# CITY OF ALBUQUERQUE

July 12, 2012

**Re: La Vista Subdivision, Grading Certification For Final Plat  
Engineer's Stamp Date 01/20/2012 (H14/D002)  
Certification Stamp Date 07/09/2012**

**CONCRETE CHANNEL**  
NO SCALE

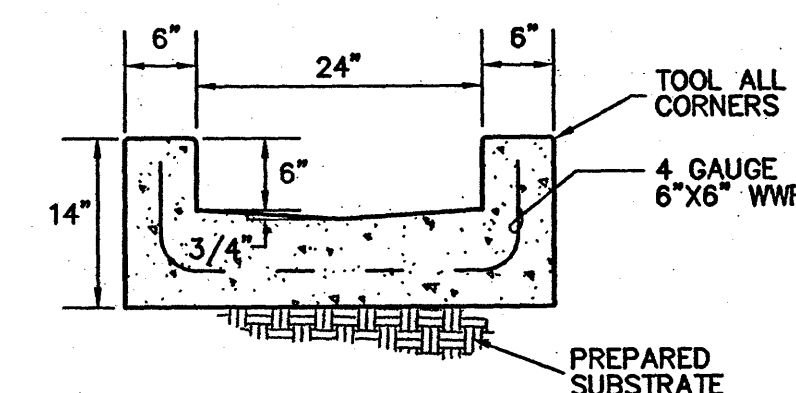
- Site conditions show signs of erosion. Please mitigate prior to final plat approval.
- The concrete channel detail does not appear to be utilized. Please note this on the record drawing as not used.

**CITY OF ALBUQUERQUE  
PUBLIC WORKS DEPARTMENT  
TRANSPORTATION DEVELOPMENT**  
**LA VISTA @ DESERT RIDGE SUBDIVISION  
GRADING AND DRAINAGE PLAN**

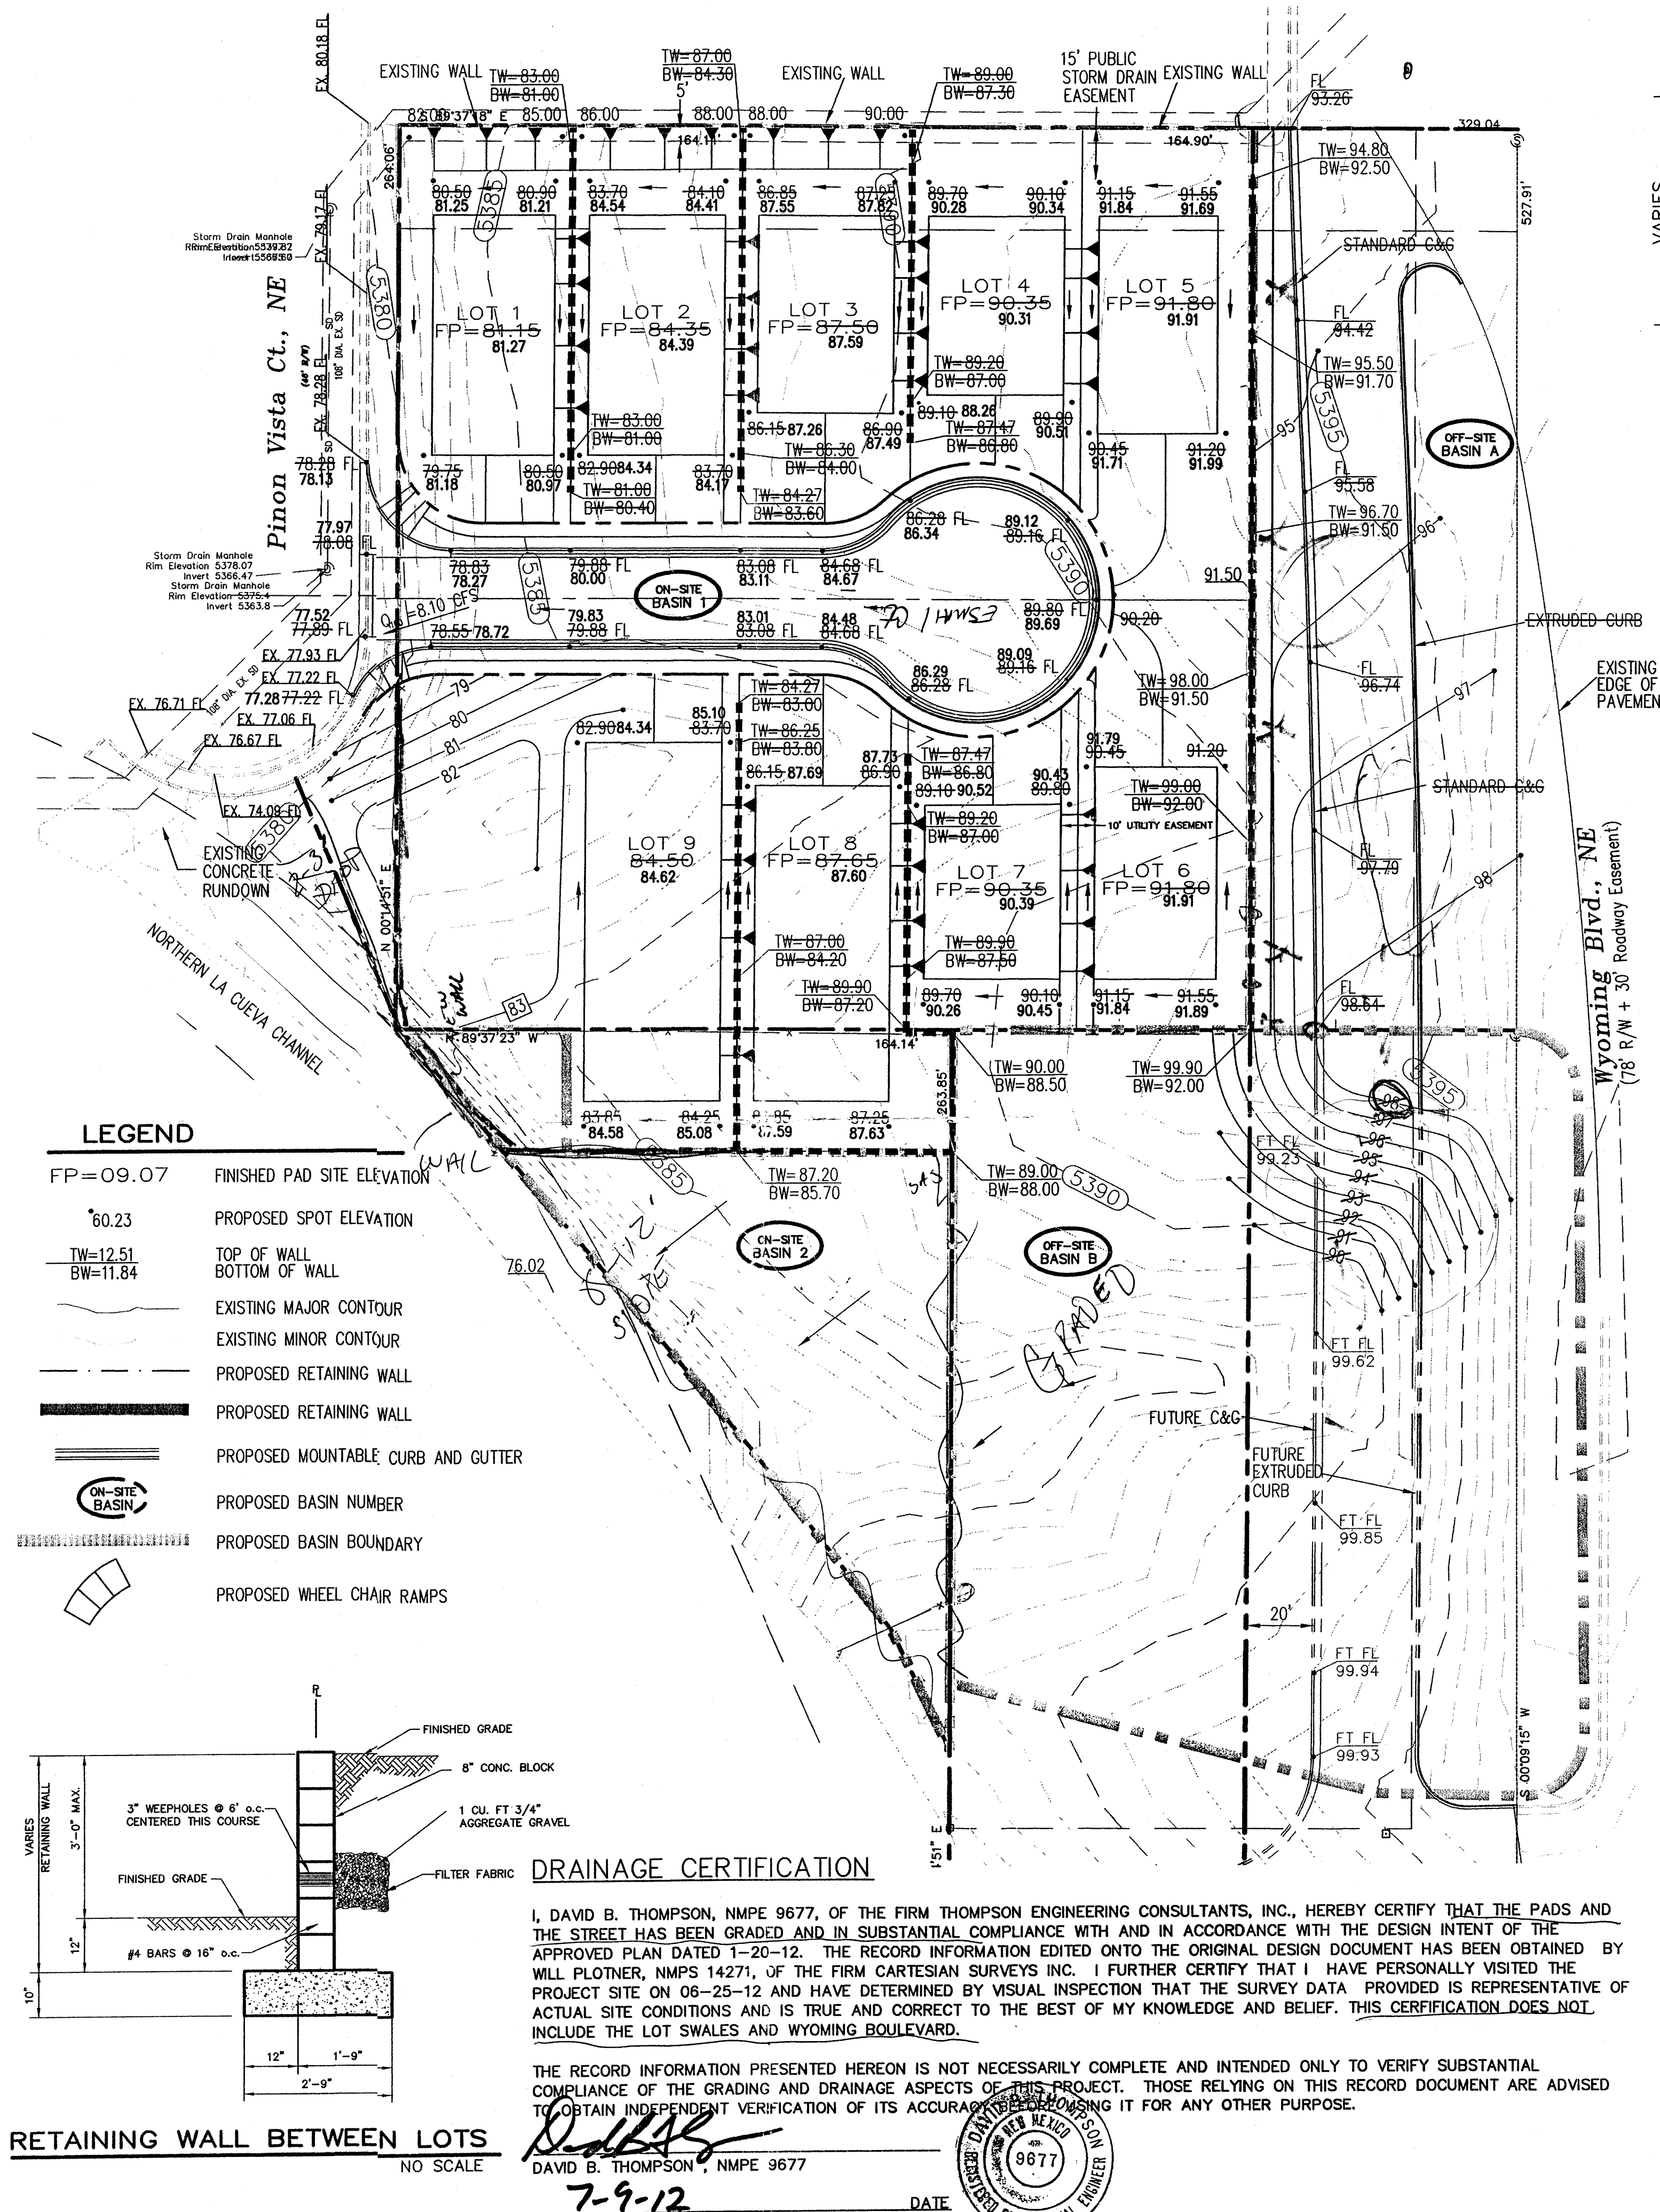
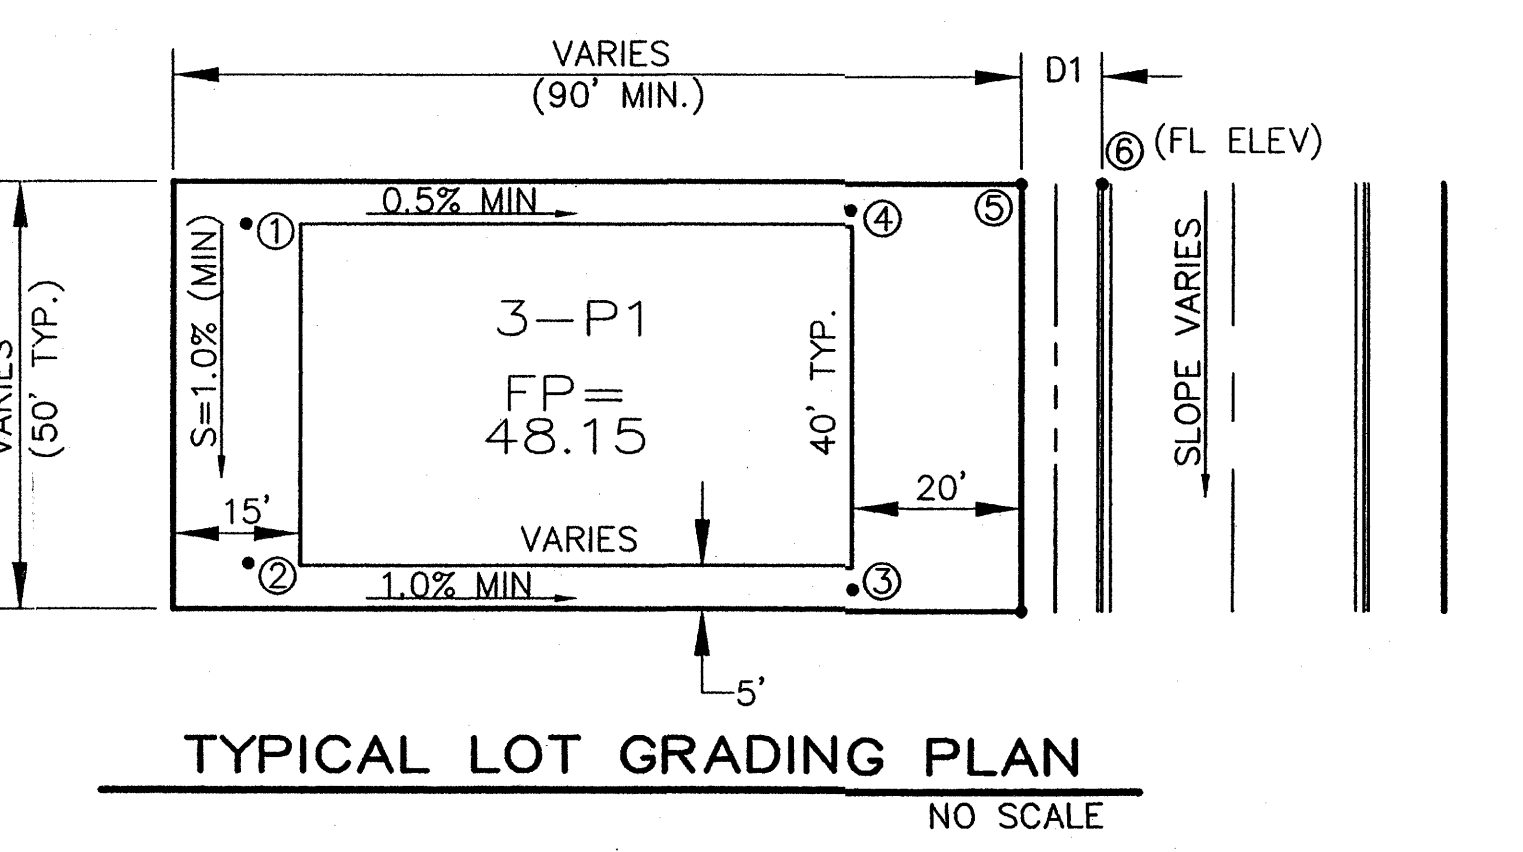
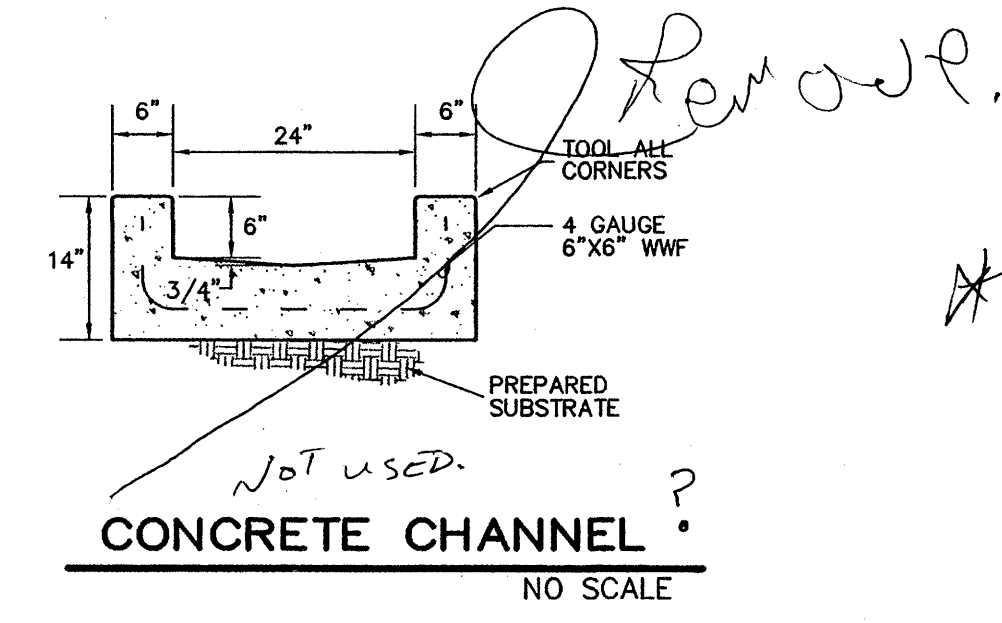
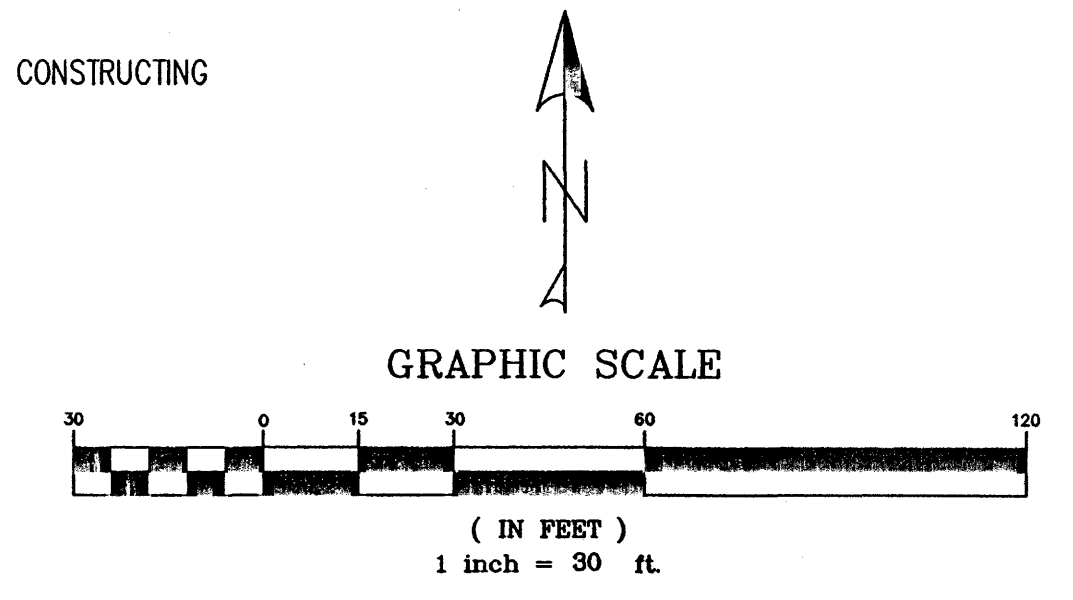
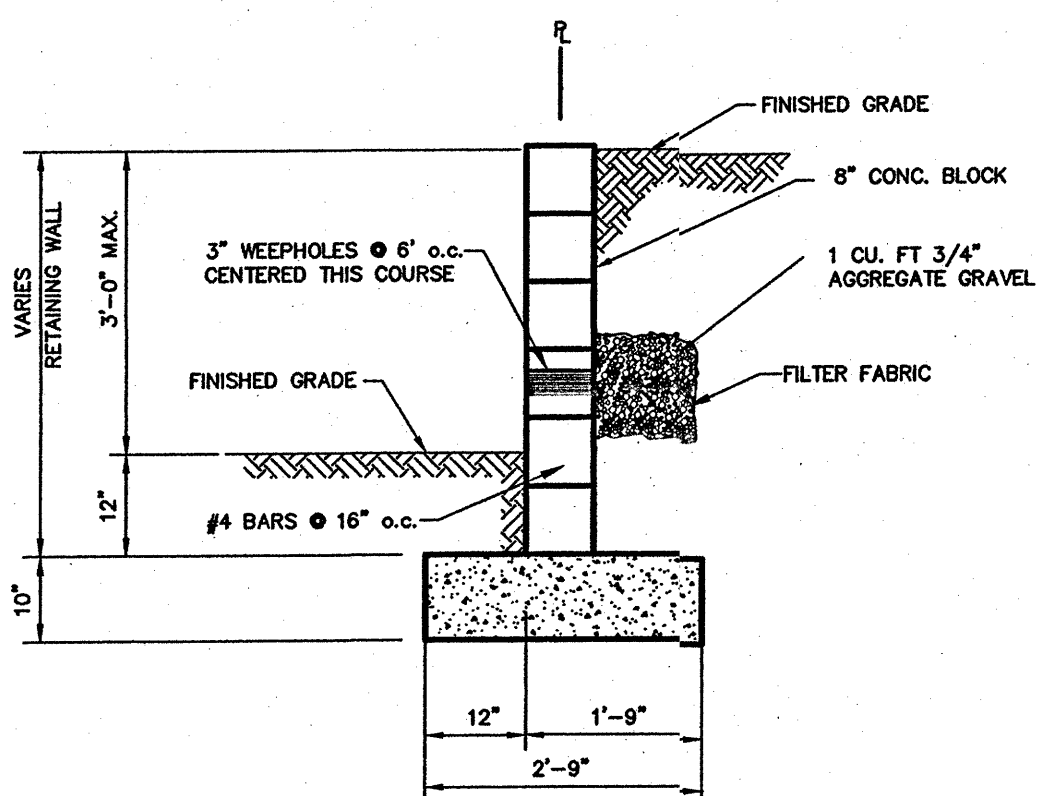
- The as-built plan does not reflect site conditions. All grading certifications should reflect as constructed condition. Also it appears the grading and drainage plan does not reflect the preliminary plat. Will this require an additional grading plan?

- Hydrology does not have a record for a wall permit being obtained. How was the southern wall constructed? Is this wall a retaining?
- Wyoming will need additional fill to comply with the design intent of this plan.

- It appears additional grading occurred outside the approved area. Please submit a plan for the grading work that is not reflected on the approved grading plan. AMAFCA's concurrence will be required for the grade change fronting the Northern La Cueva Channel. Additional slope stabilization is warranted.

- In an e-mail from Mr. Cherne, dated 06-21-12, "your certification will require a note, under Note 1, that states "A separate Engineer's Certification is required to obtain a building permit for lots 1, 2, 3, 4, 7, 8, and 9." Please add this note.
